Comments on Planning Application
Reference 6/2021/0079/Full

8 Hill Rise, Cuffley, Potters Bar, EN6 4EE

Project Address	8 Hill Rise, Potters Bar, EN6 4EE
Sheet Title	As Built 3D Front View
Sheet Number	A107
Paper Size	A1
Revision	
Issue Date	01/01/2021

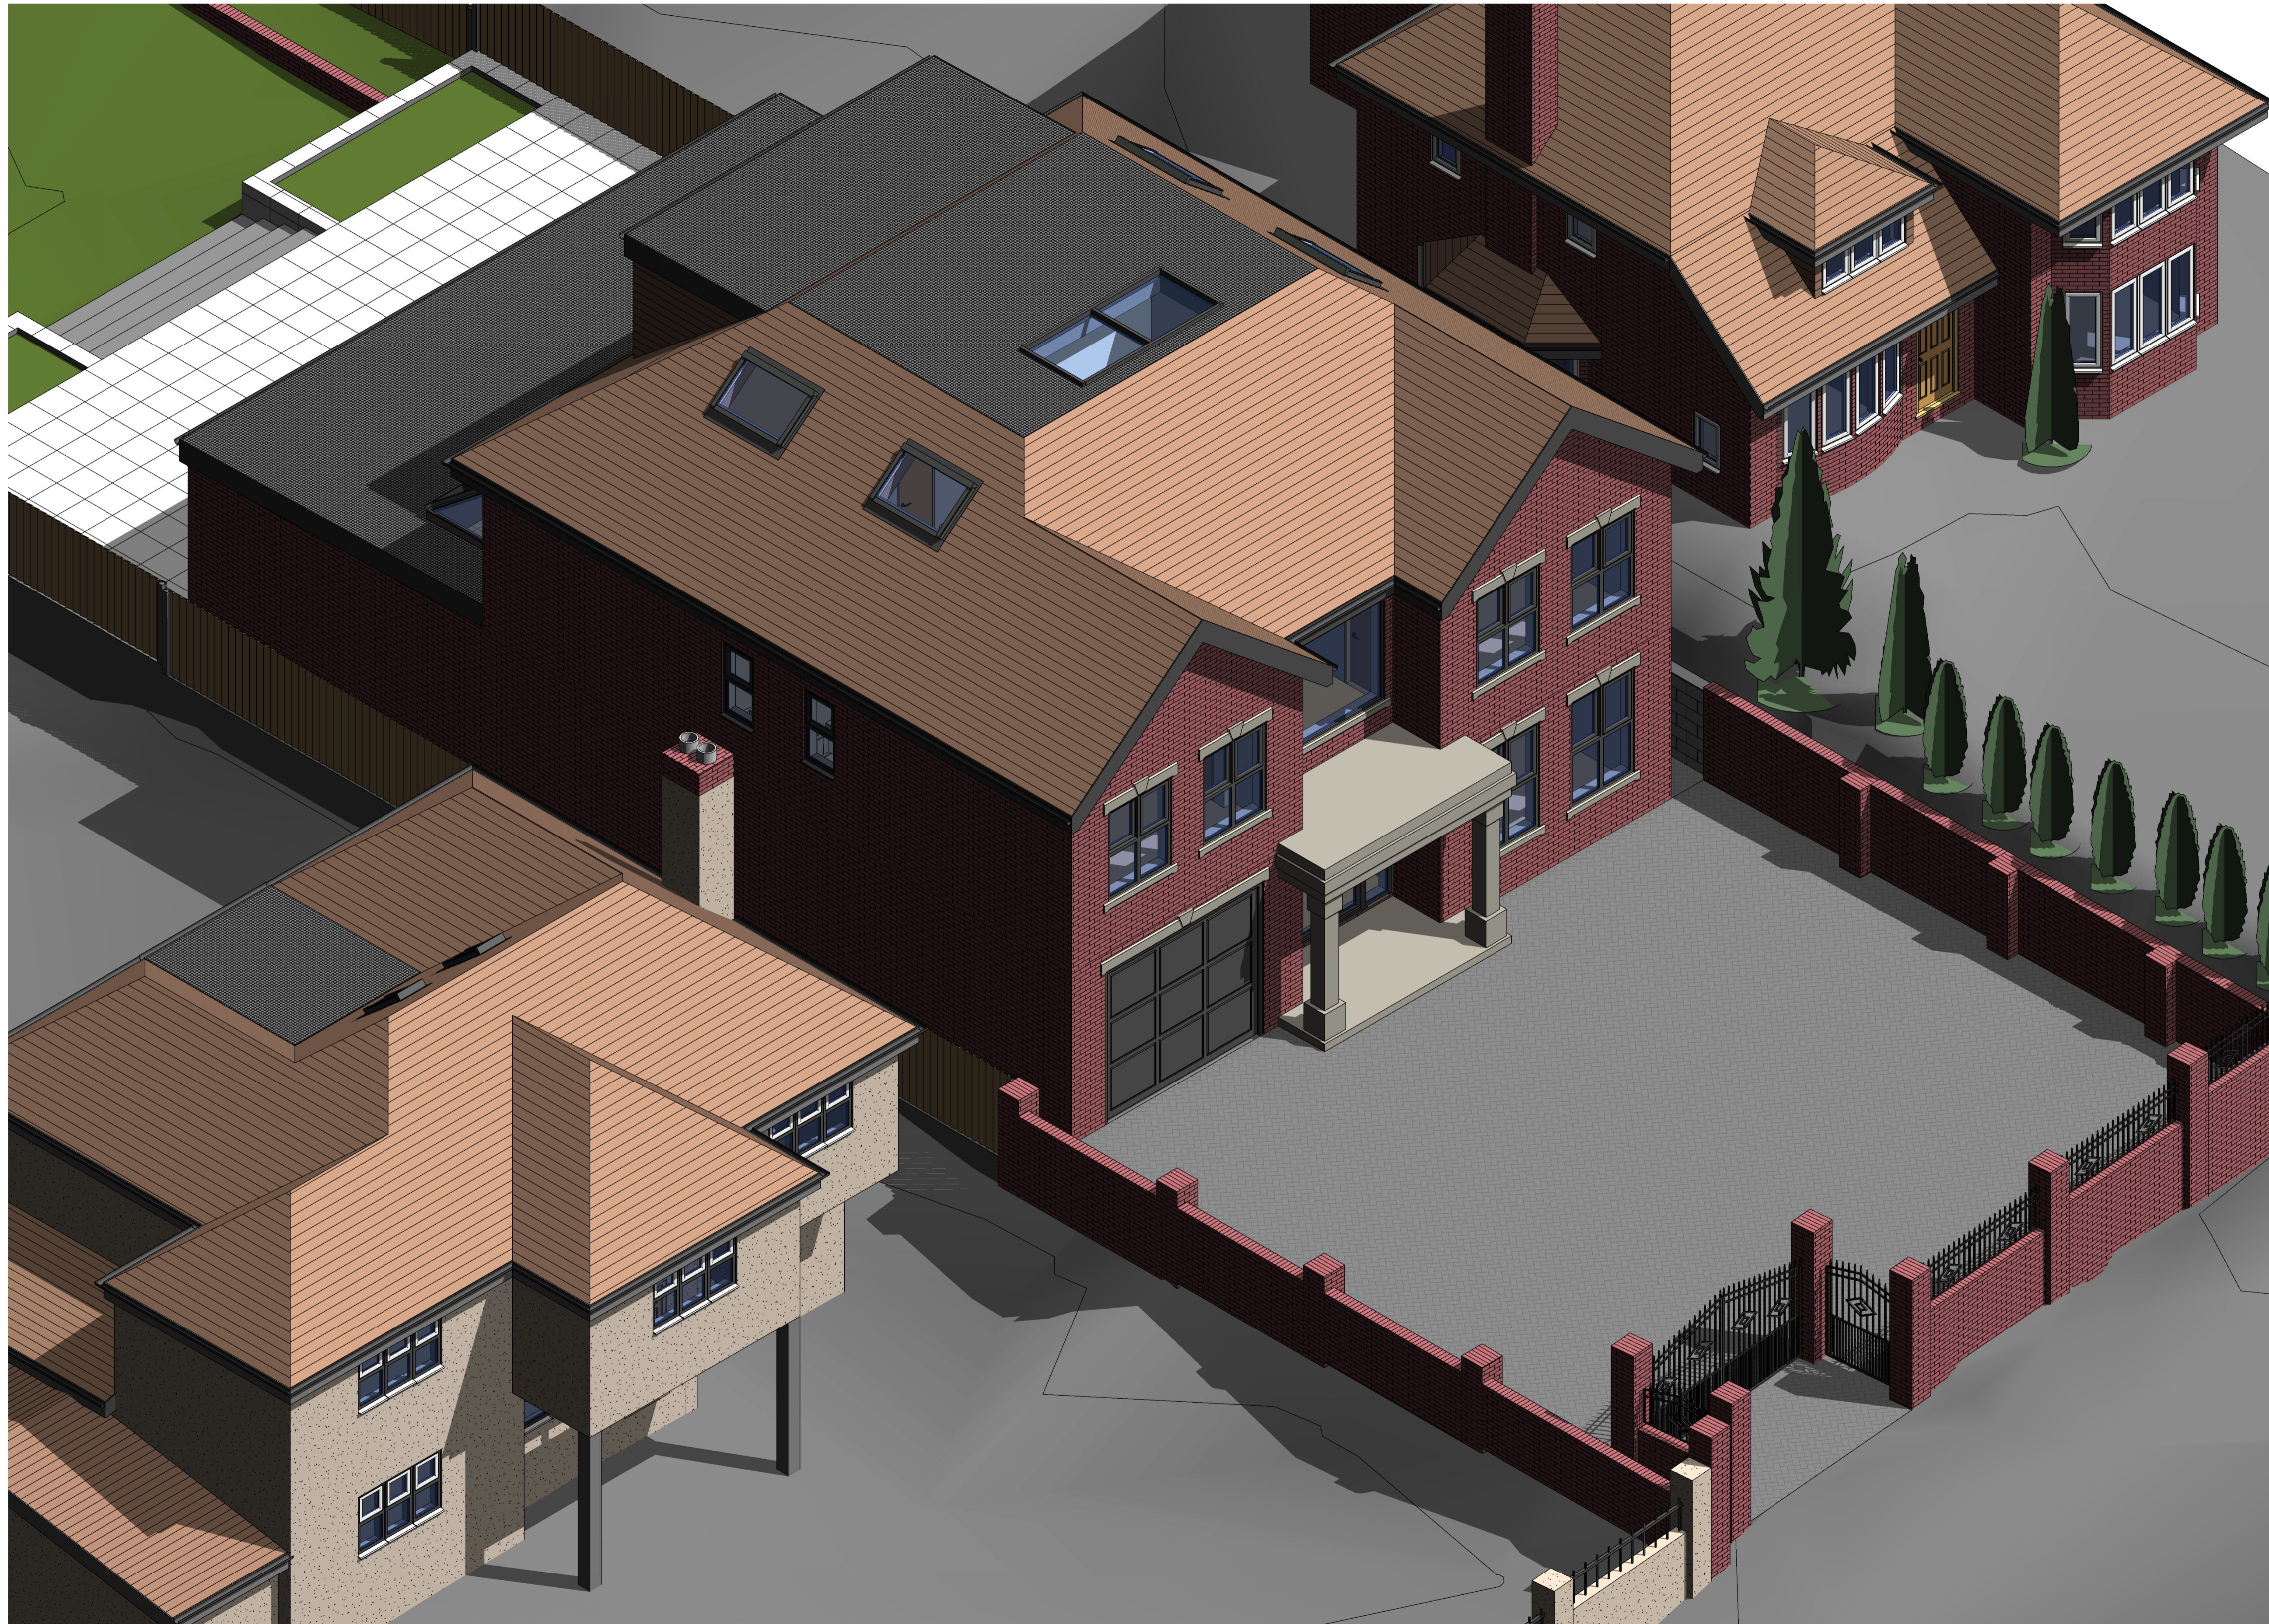
- Unique size & scale.
- Various breaches of the original planning consent detailed in the attached scanned drawings.
- Lack of replacement soft landscaping.
- Candid two way views through its front elevation windows, due to the unduly large areas of clear glass that do not accord with the original window design in either style, colour or material.
